RE: Rudino's Cameron

A plan review was received by this office concerning the construction of the above referenced facility. The plans are not approved at this time with the following comments:

**FLOOR PLAN - RETAIL BUILDING**  
SCALE: 1/8" = 1'-0"  
TRUE NORTH

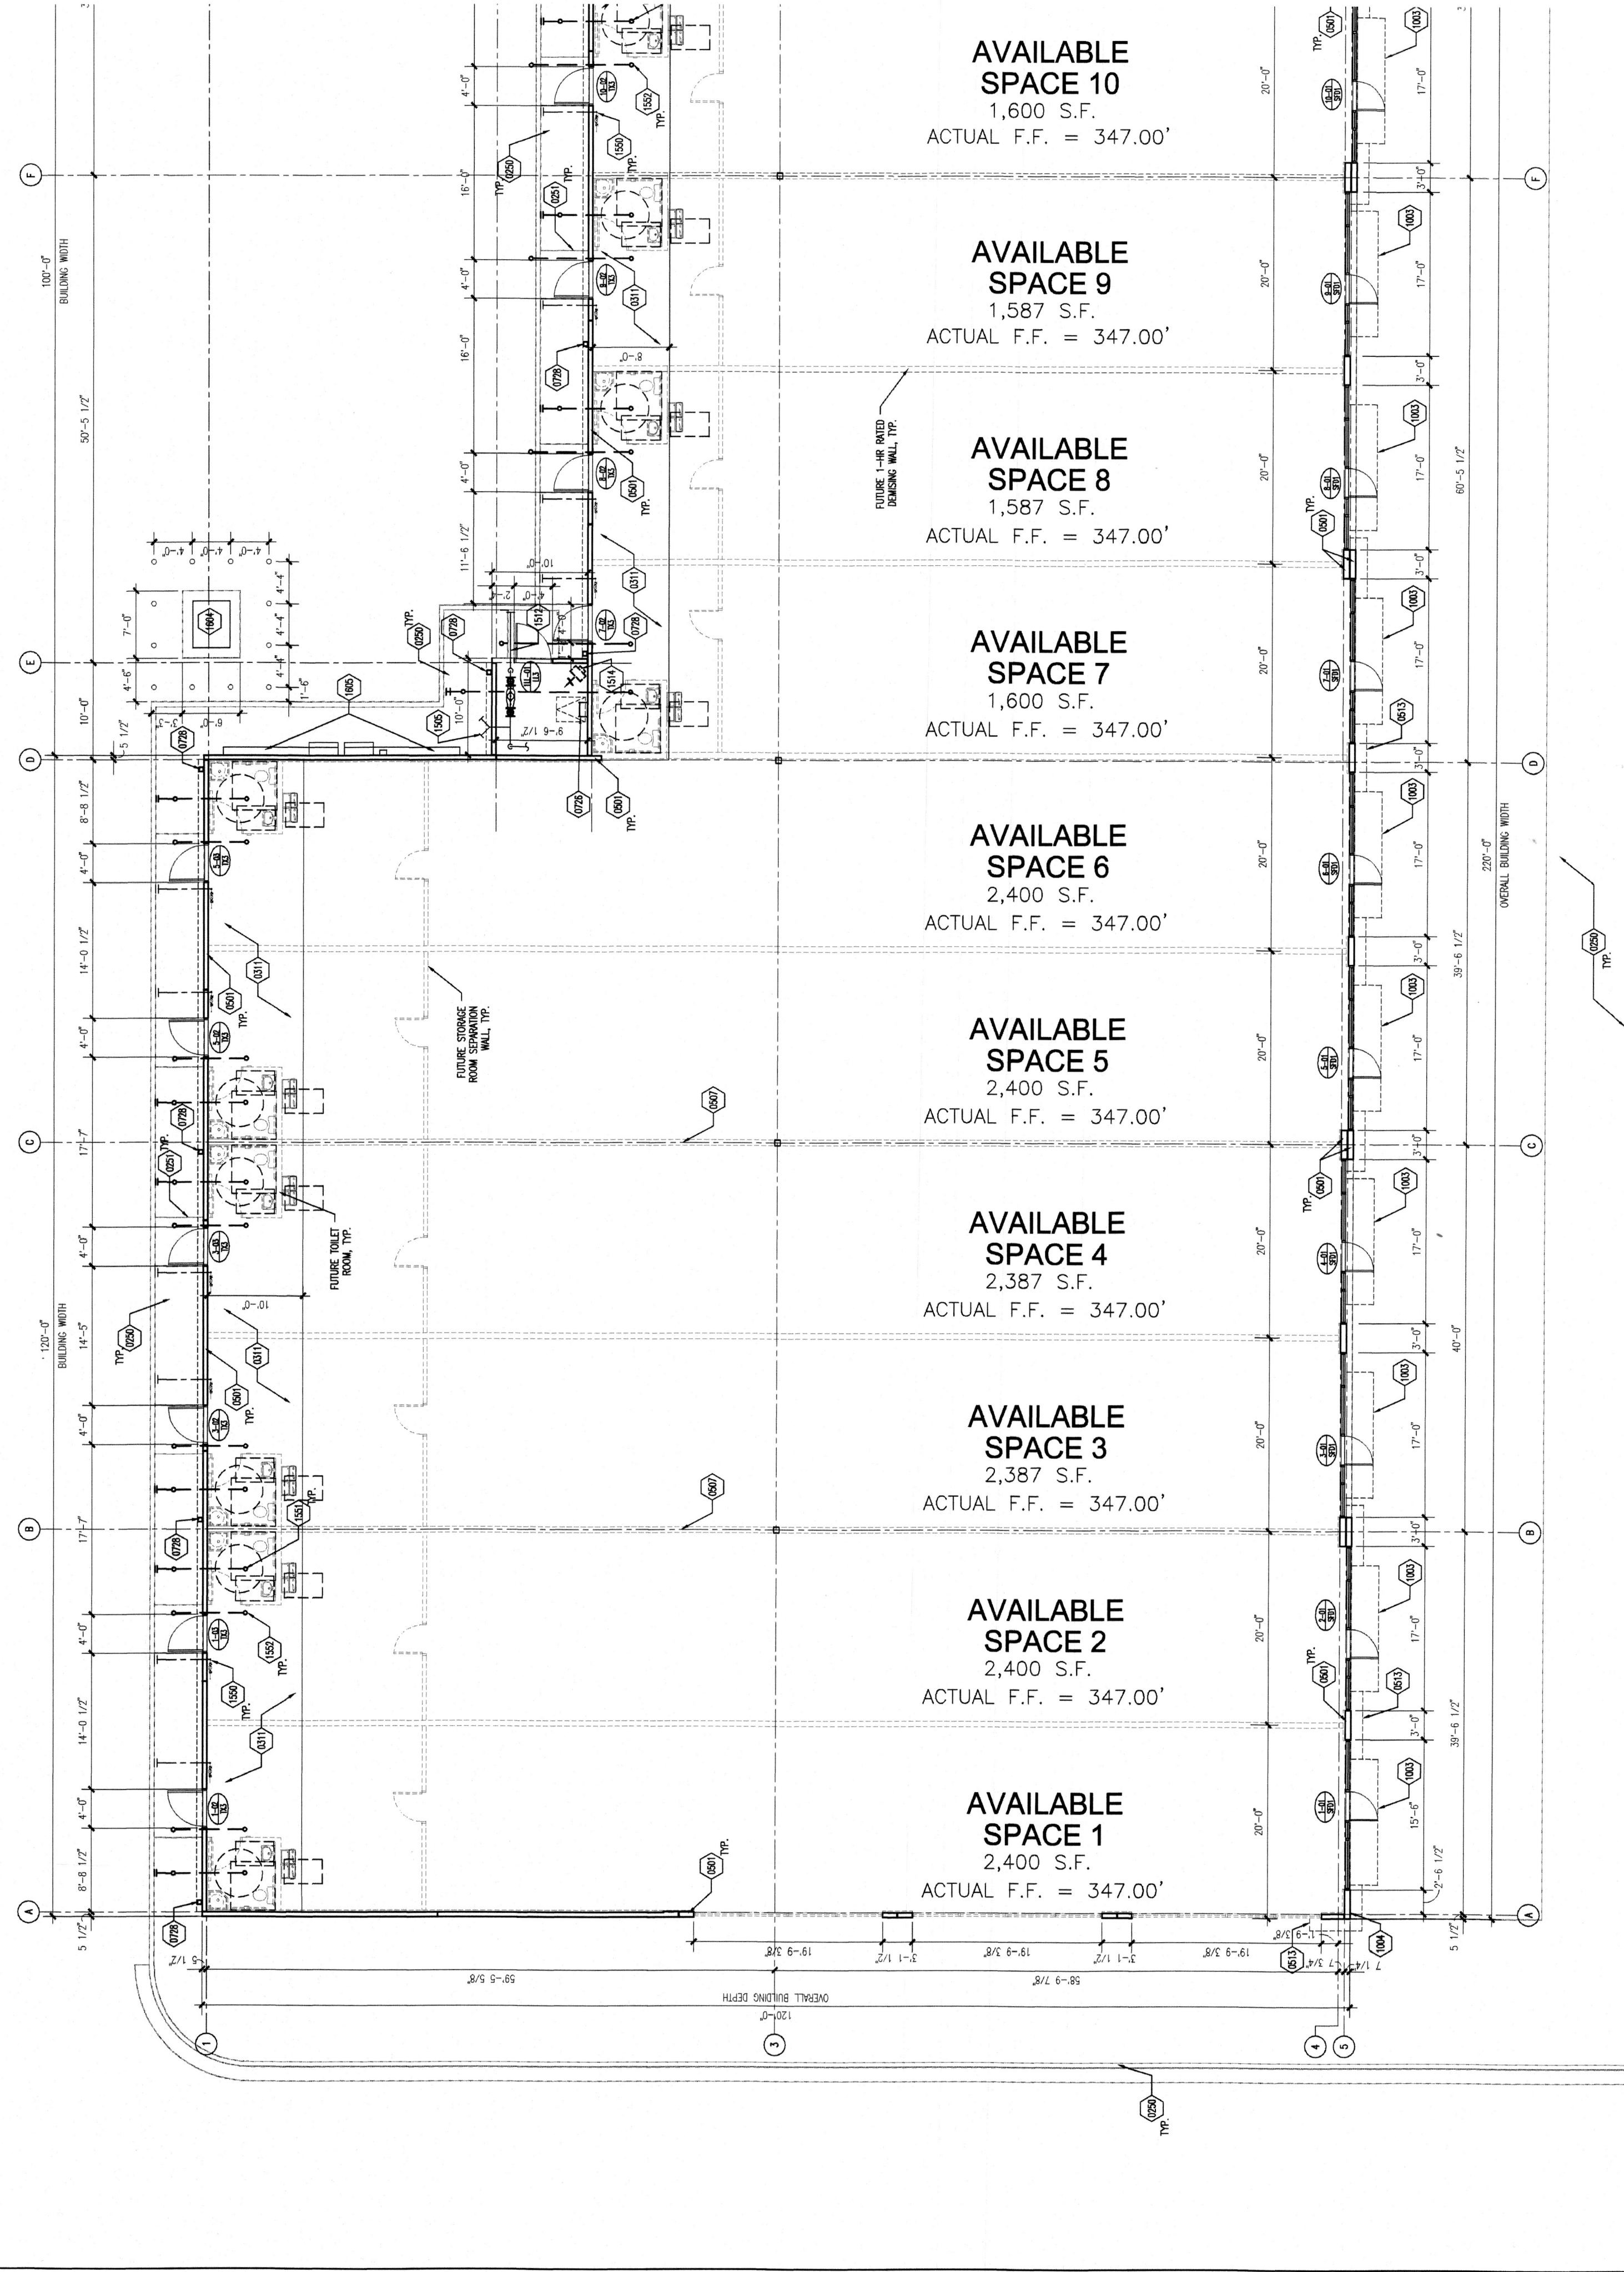
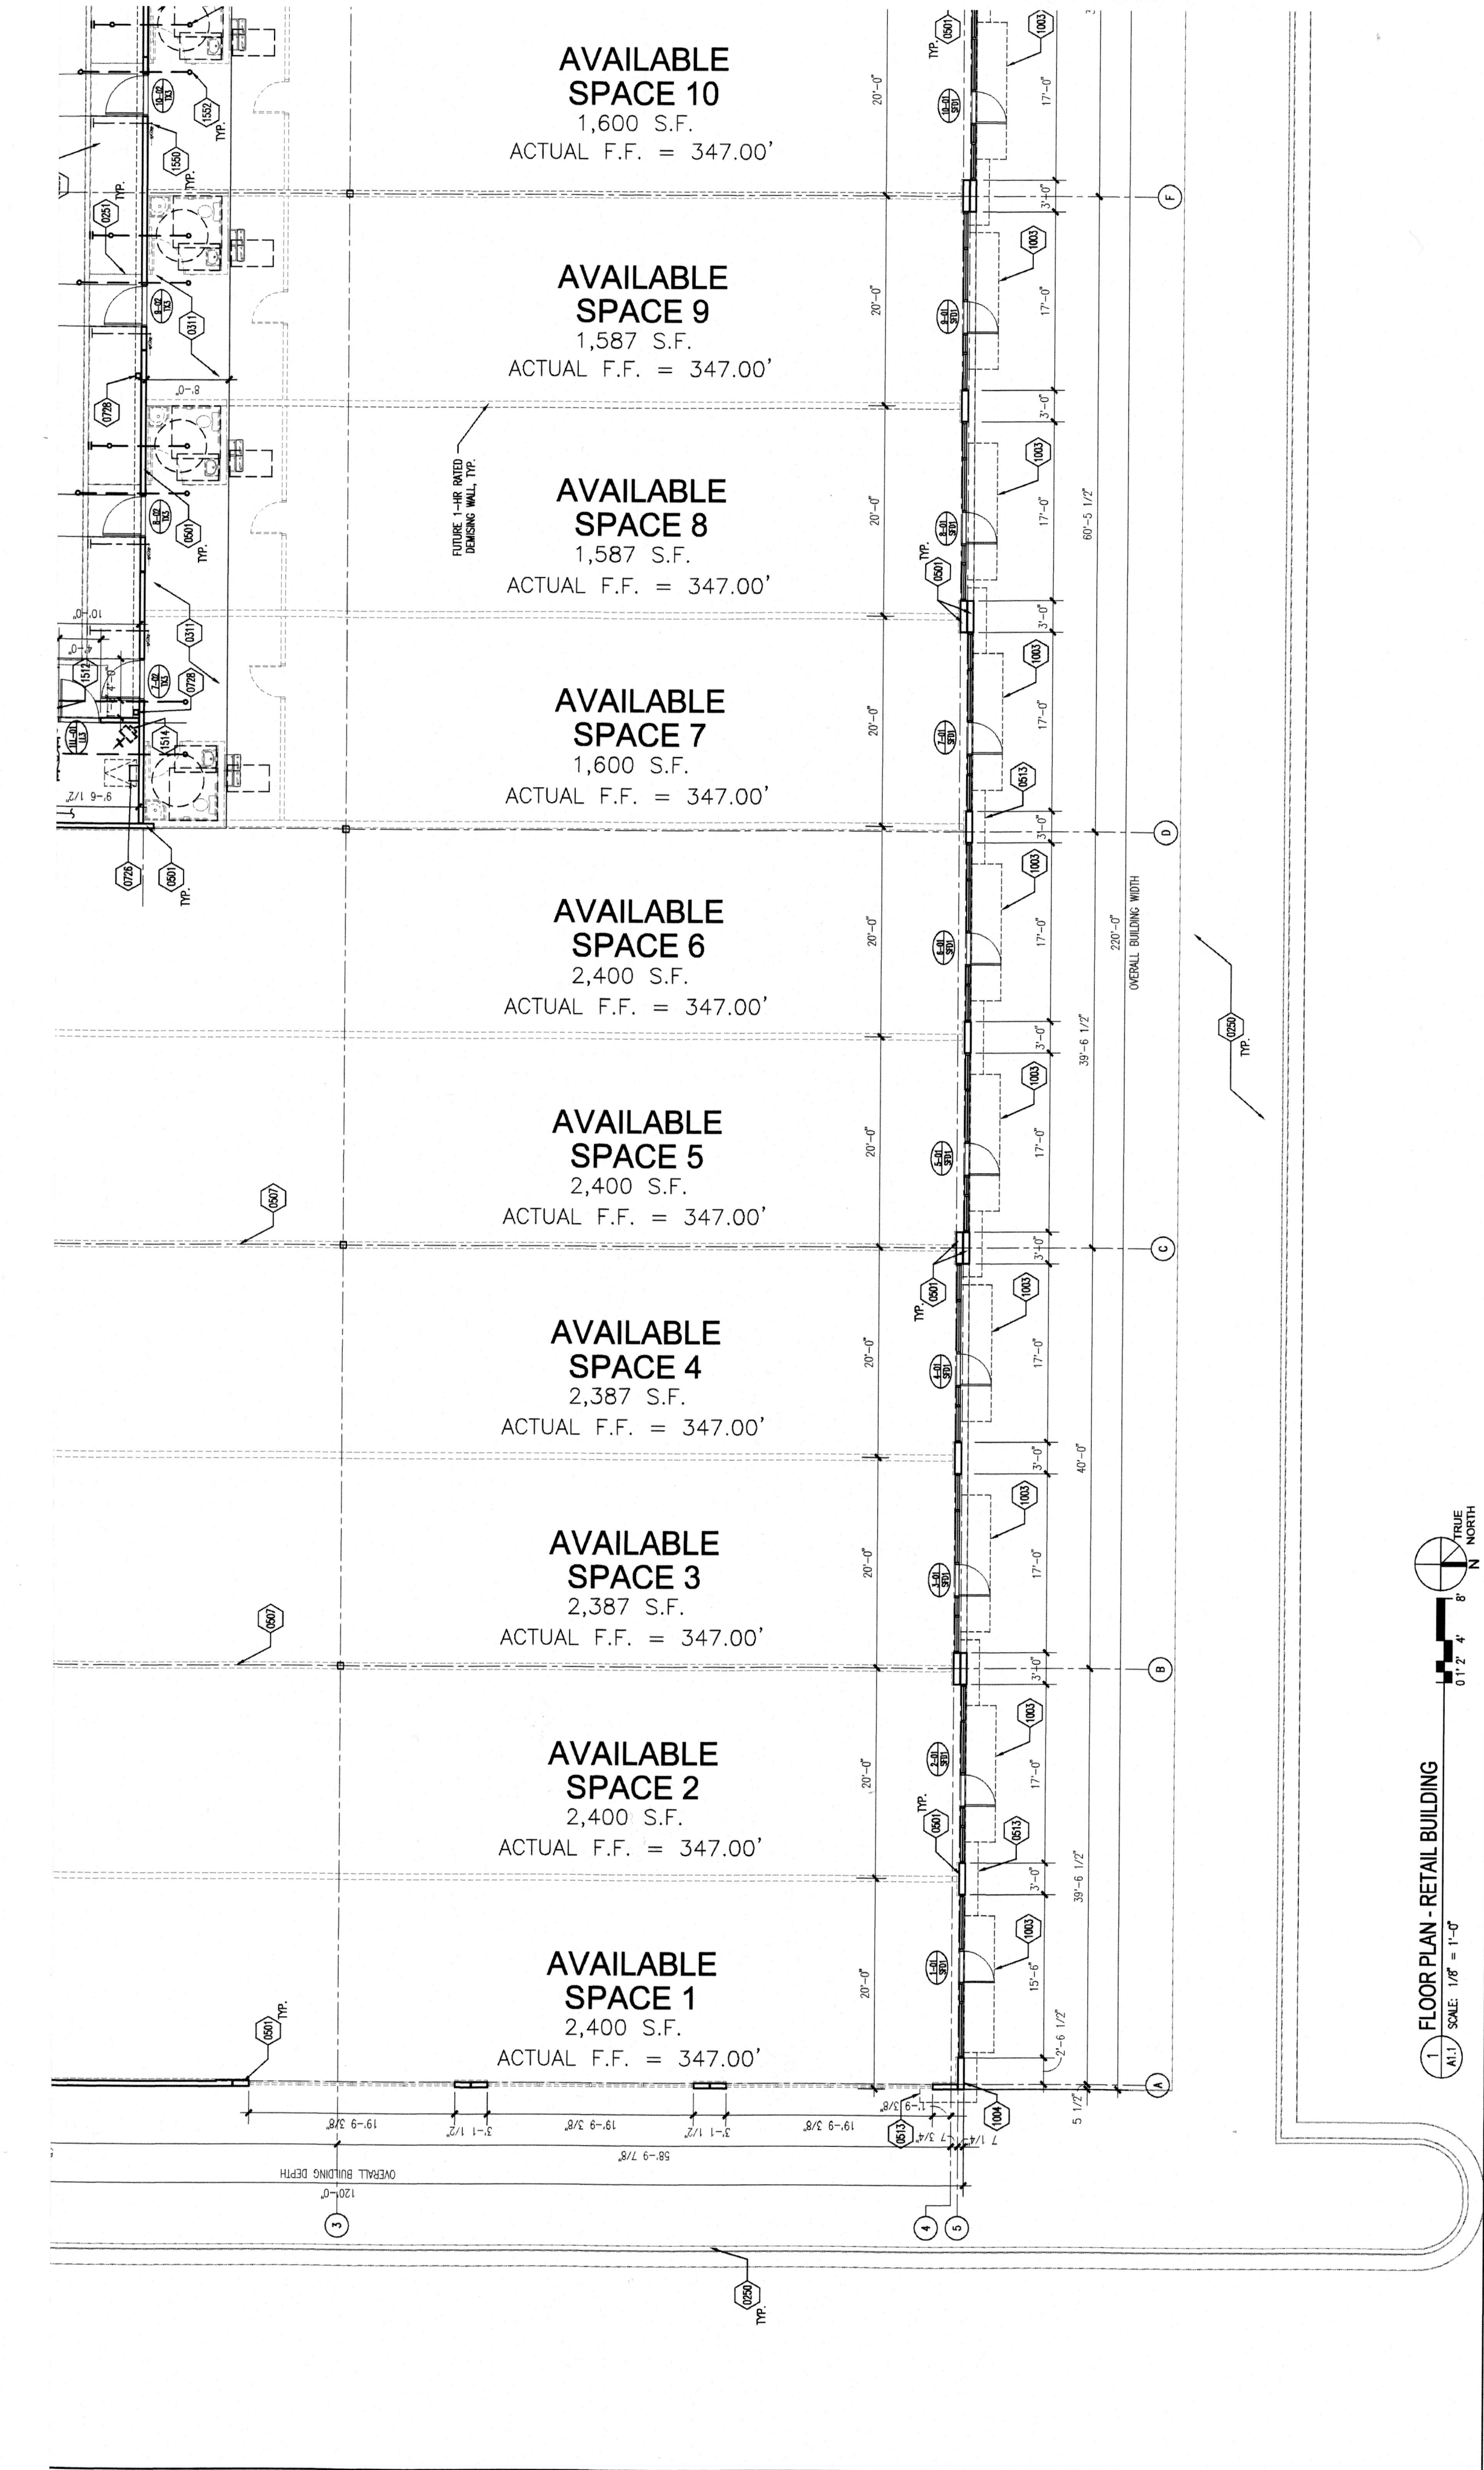
- The floor plan/equipment layout is not drawn to a recognizable scale.
- Equipment shown on the floor plan is not complete. Specification sheets were received for equipment that was not subsequently shown on floor plan. Items include but are not limited to tabletop warmers, hot holding cabinet, reach-in freezer.

- Indicate what is in the place where the interior walk-in was previously located.
- No specification sheet was received for the following pieces of equipment: three comp sink, food prep sinks, shelving, dish machine and raceways, water heaters and walk-in cooler.

- Where will empty kegs be stored? Will there be keg storage in the walk-in cooler?
- The food prep sinks appear to overlap. This is not an approved arrangement.

- Please indicate the use of the sink located in the bar area.
- The exterior walk-in does not enter directly into the kitchen area. This unit will therefore be for food delivered and received that is packaged. The walk-in will be for long term storage only and cannot be used as a working refrigeration unit.
